**Consultation Response from Mike Hibbert,  
KC Waste Strategy( Refuse & Recycling)**

**2021/93621 Land off, Fullwood Drive, Golcar, Huddersfield, HD7 4JH**

**Erection of 12 dwellings and associated works (Within a Conservation Area)**

**Date Responded: 14/3/2023.**

Project No: 2673 Drawing No: (100)03 Rev: L

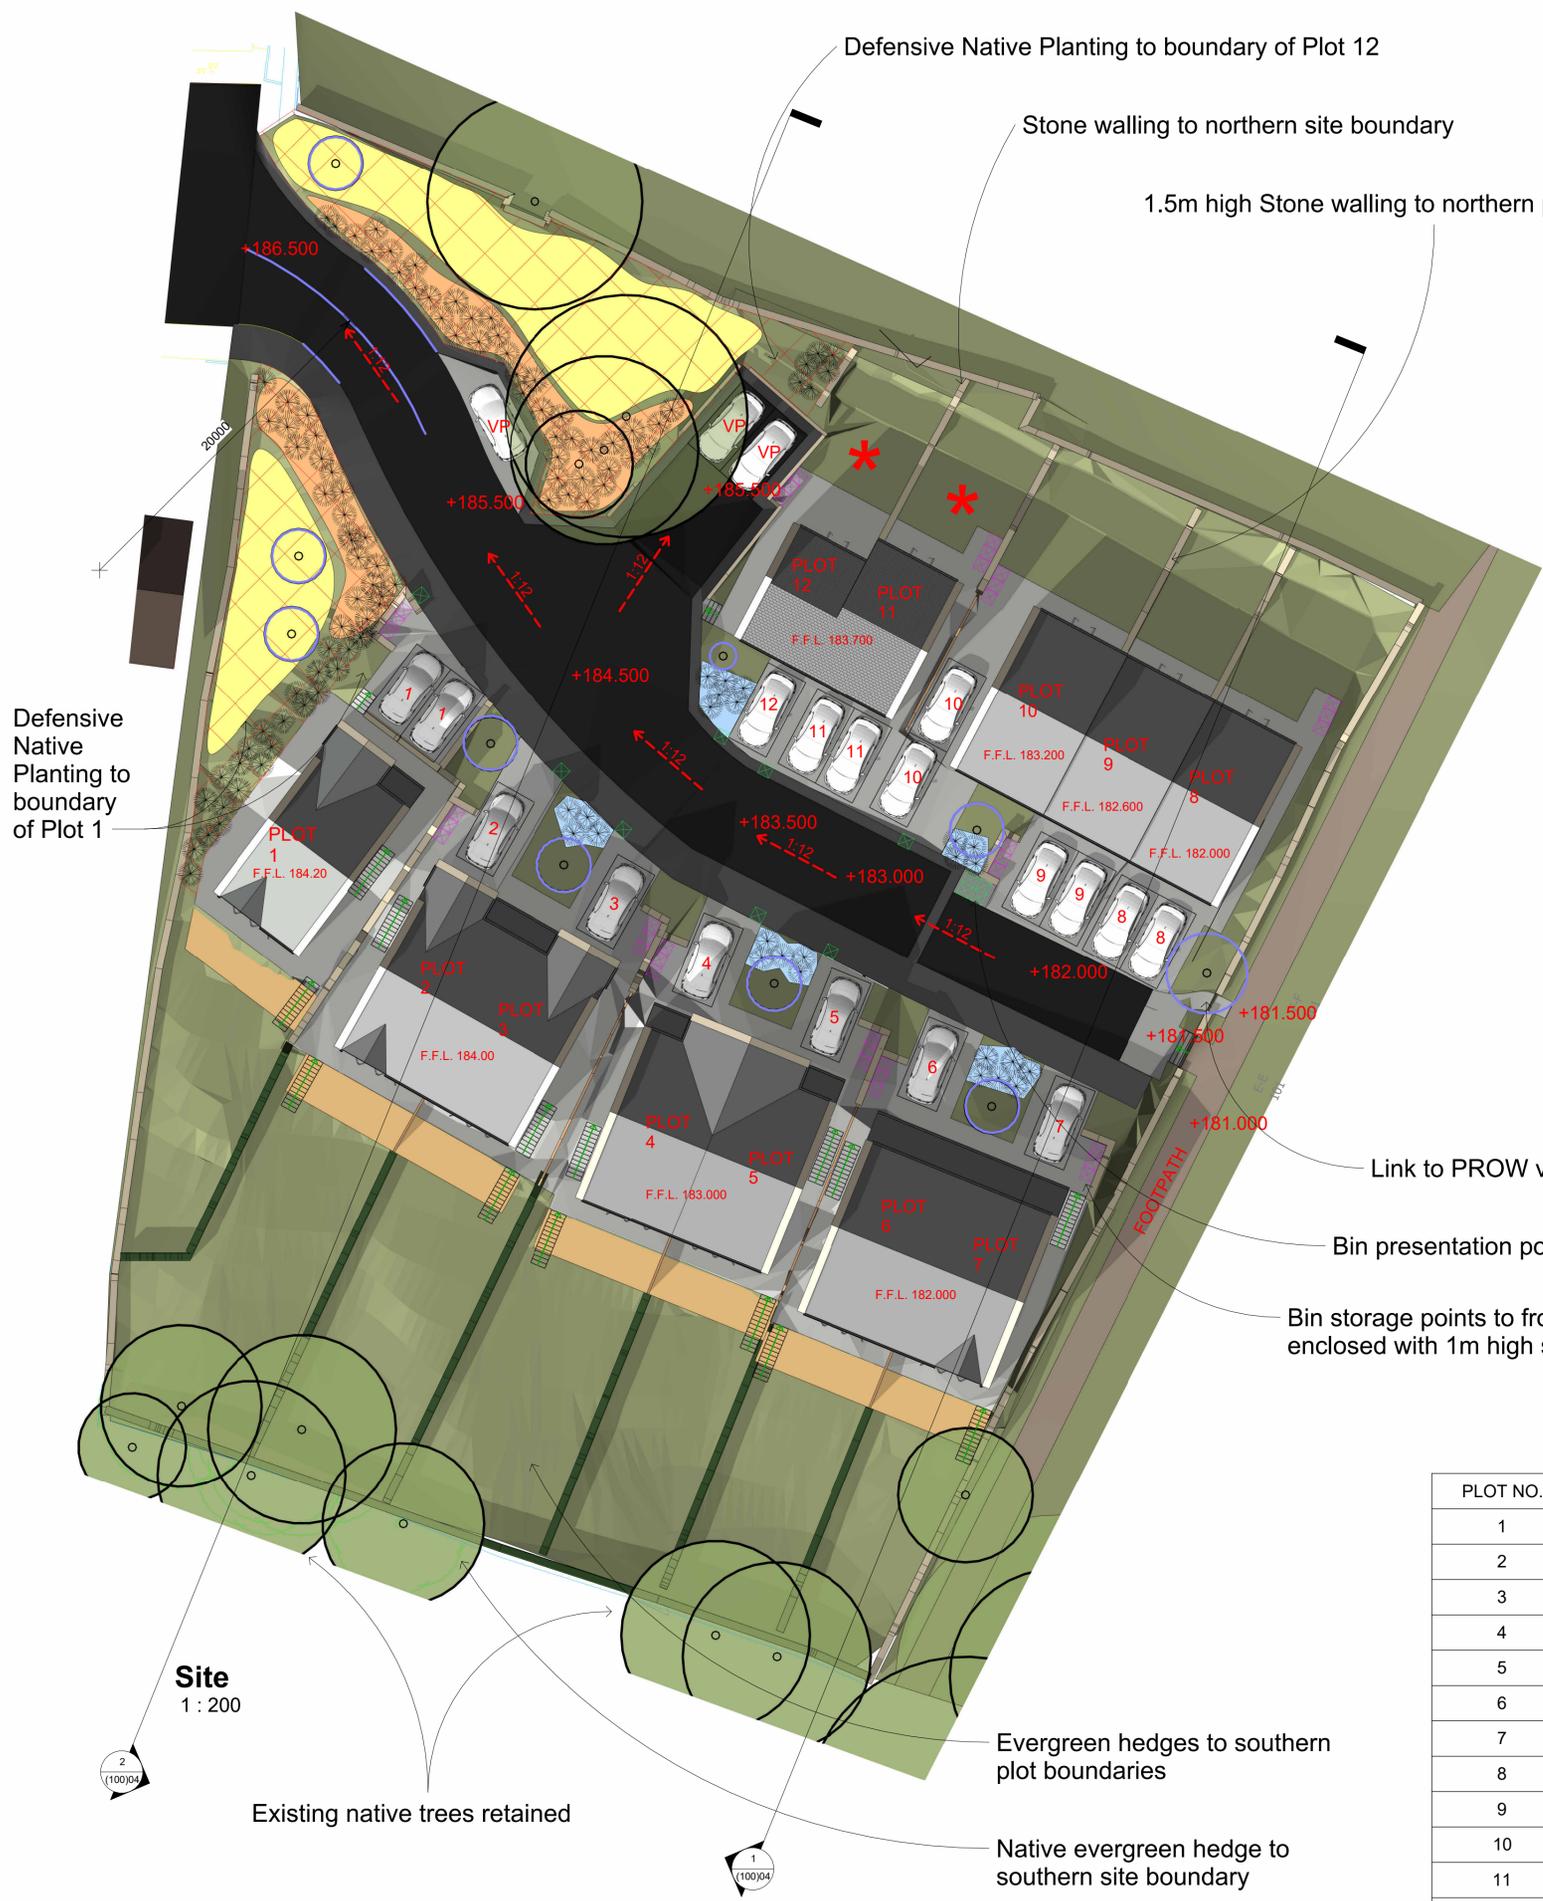
The application in the section on Waste Storage and collection states “Bin storage and collection points provided”. The applicant has submitted proposed site plan & 3D View ref dwg No (100) 03 Rev C dated 3.3.2023 but this does not show any detailed waste storage or collection information other than a Bin Collection Point (BCP) adjacent to Plot 9. These comments are therefore broad, and any further proposals should be developed in line with the Authority’s published guidelines (see below).

- The development site slopes down in a South Westerly direction and to provide access the properties on Plots 1-7 are Split level over three storeys with gardens below road level. On this basis bin storage avoiding keeping bins under windows/close to doors will need to be provided at the side or front of properties to negate the need to take bins up/down steps to reach rear gardens. Any such storage would be set within the Streetscene and therefore should be screened and secured to prevent bin blight, the spread of waste into the street, unauthorised use and theft/damage to bins.

- Plots 8-12 appear to be at the same level as the road access. Bin storage should be in rear gardens with gated access that should be shown to be secure and the route between the rear gardens and the front access road must not require residents to pull

bins up/down steps or gradients of more than 1:12. If this is not achievable then storage to the front of the properties is required.

- The 3 properties on plots 8-10 form a terrace. Bin storage to the rear of properties is preferable but must be easily accessible for residents and not be reached via convoluted pathways routed across the back of multiple other properties as this discourages residents from returning bins to the rear, resulting in bin blight in the Streetscene. If rear storage is not viable there will need to be a bin storage location at the front of the property.

- There is no indication of space for the presentation of bins on collection day. It is important to ensure that bins do not cause obstruction to pedestrians or other highways users when presented for collection, particularly where space requires these to be left in clusters. Bin presentation space should be identified for each plot, on a hard surface and where a refuse collection vehicle (RCV) can be easily reached.

- The Authority will not take an RCV into private drives or roads that are not built to adoptable standards.
- Plots 6-9 are located on a private drive. Shared private drives will require communal presentation points for bins as shown on the drawing. These must be large enough for the number of bins to be collected and be on level, hard surfaces such that grouped bins do not cause obstruction to the highway, drives or pedestrian movement on collection day.

- Visitor parking is shown on the layout plan next to the turning head. Parked cars are a perpetual problem for RCV access and as such it is important to account for potential parking spaces, even where these are undefined when assessing RCV access around the site. Active measures should be adopted to prevent parking in the turning head as this would not be visible when the RCV enters the development and if blocked would require an RCV to undertake a long reversing manoeuvre that is a recognised safety risk.
